Responses to comments for: K15D011

A1 SITE PLAN  
1"=10'

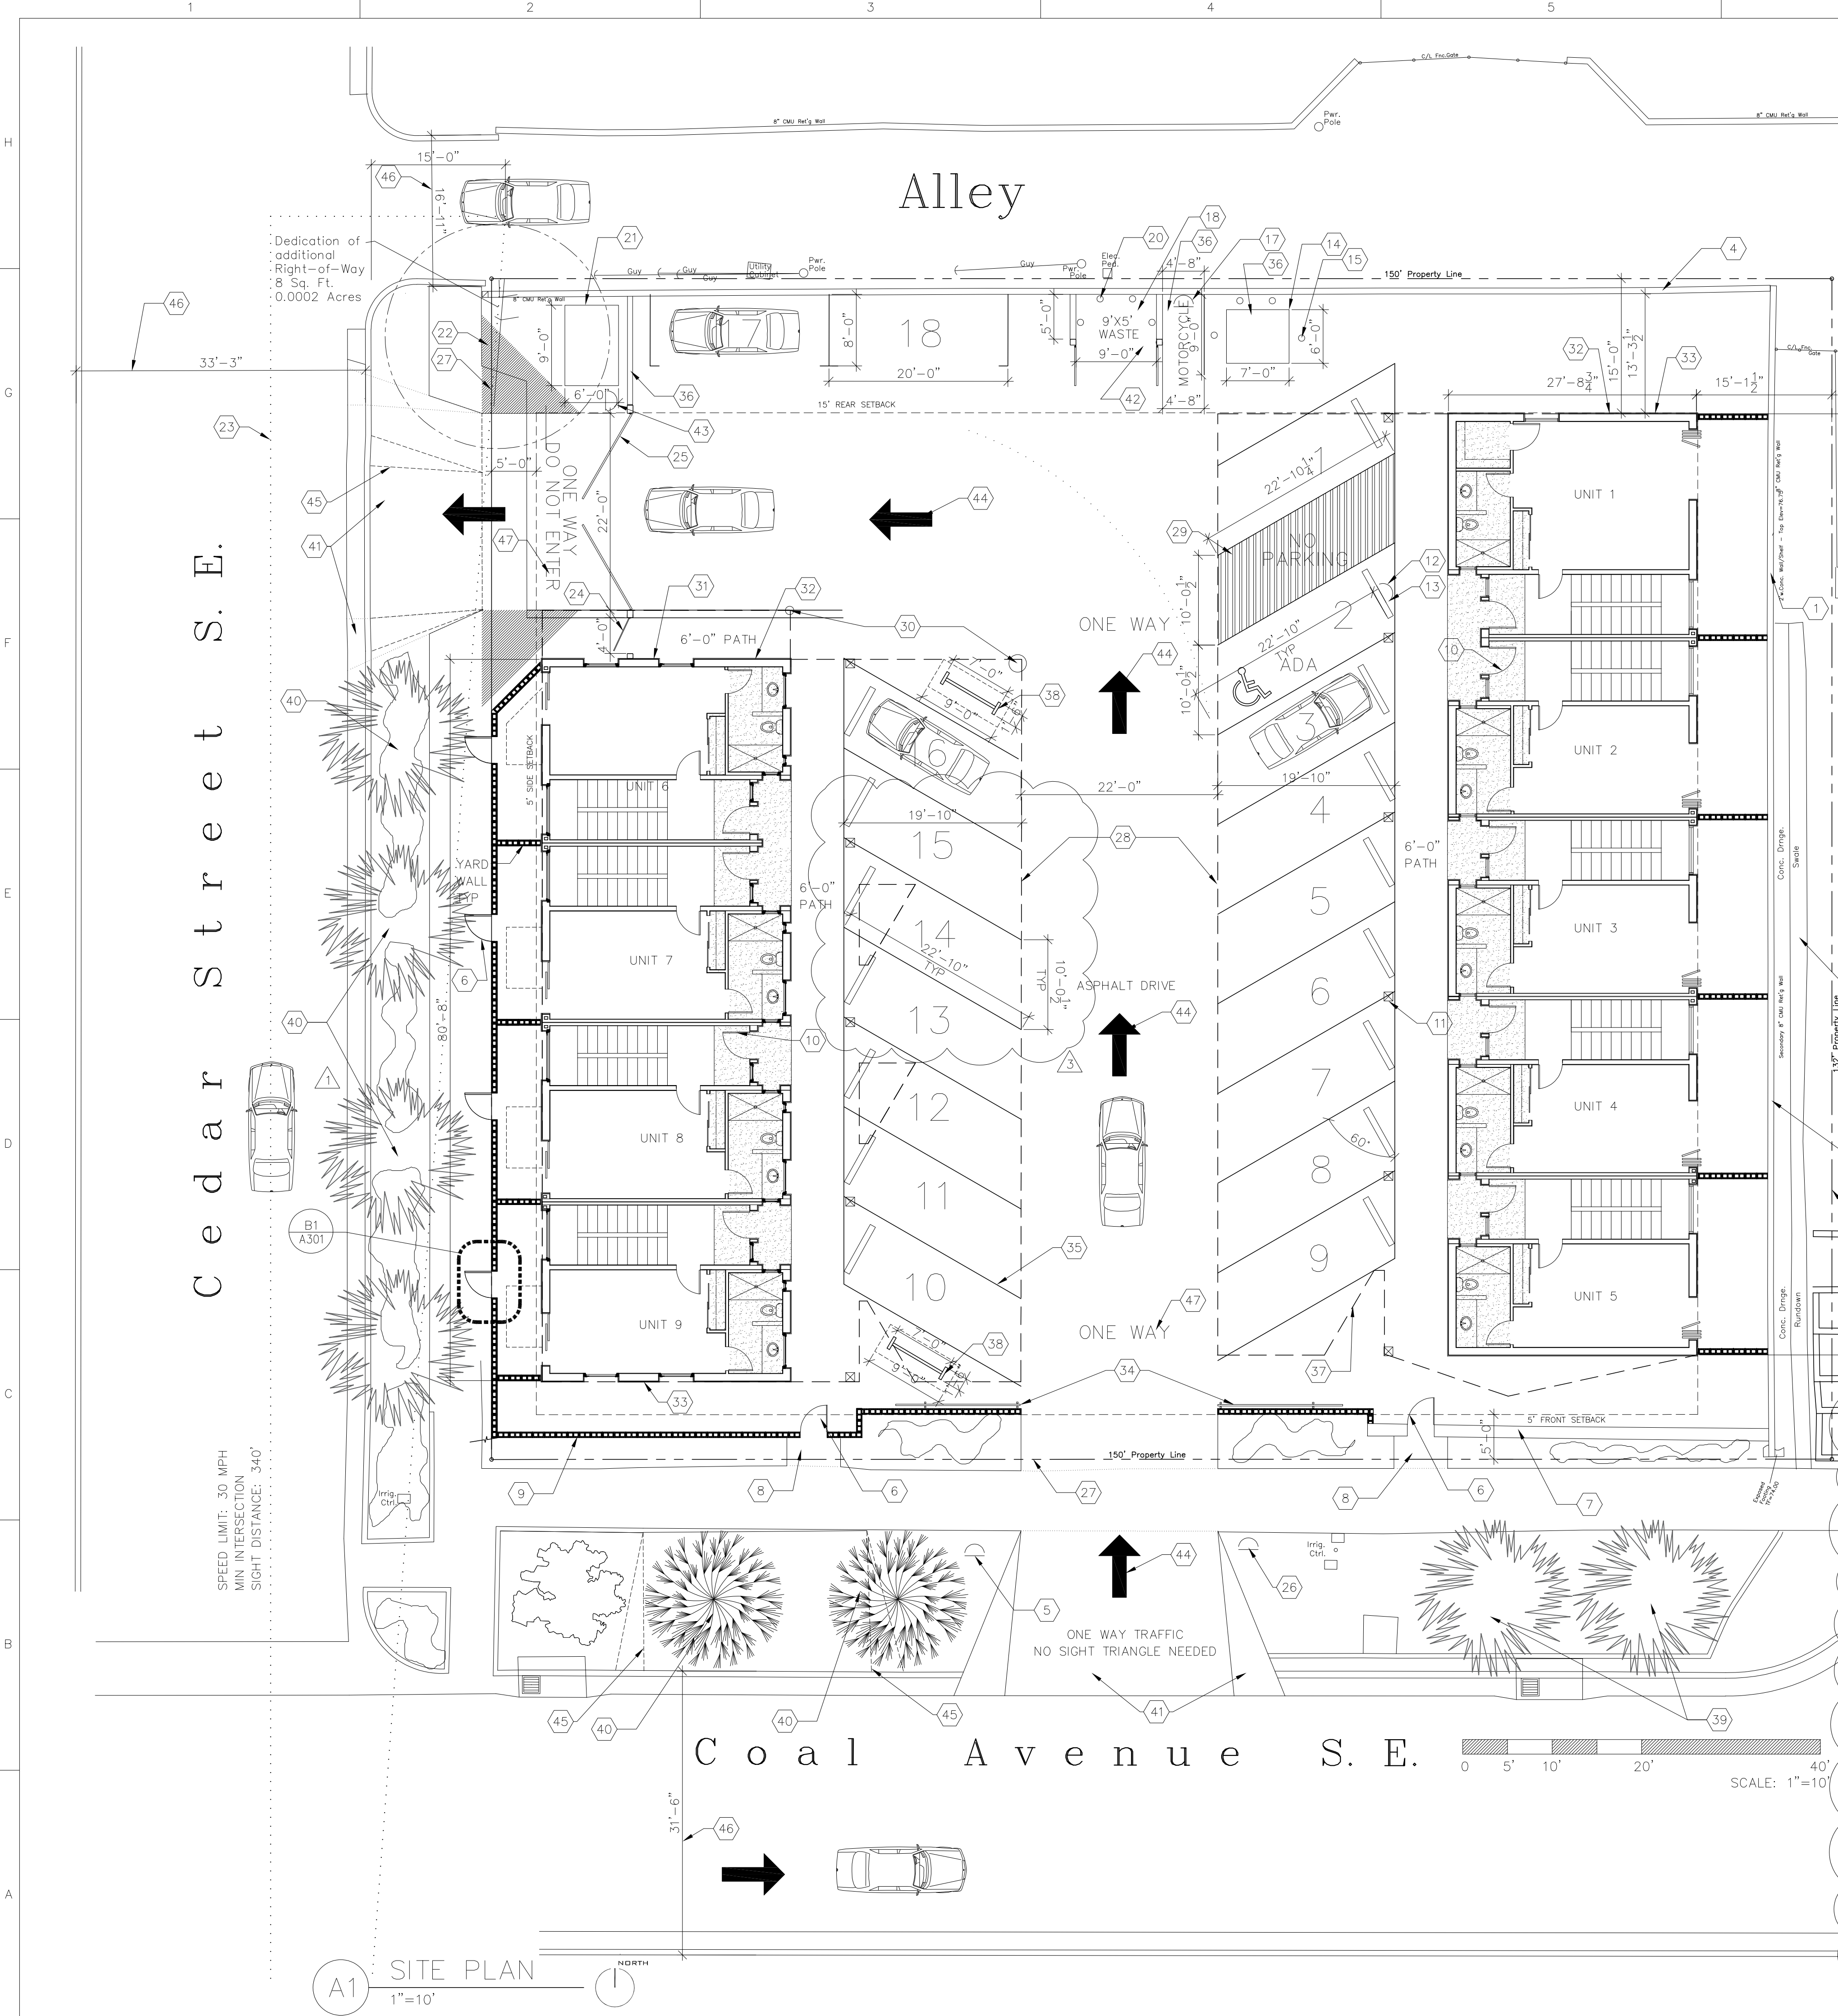
1. Vicinity Map is attached. Labelled on separate sheet AS101A. It is clouded with a delta 2 marking the update.
2. ADA note 5 is updated to reflect the signage requirements. It is clouded with a delta 2 marking the update.
3. All parking is 60 degrees. That is noted on the site plan. It is clouded with a delta 2 marking the update.
4. Approved fireplan 1 is attached.
5. Plan that was submitted to Herman for approval (reflects the location of waste) is attached in this e-mail. Additionally, I forwarded Herman's e-mail stating his approval of the waste for the purposes of the TCL. He noted this plan will be submitted again when we submit for building permit.
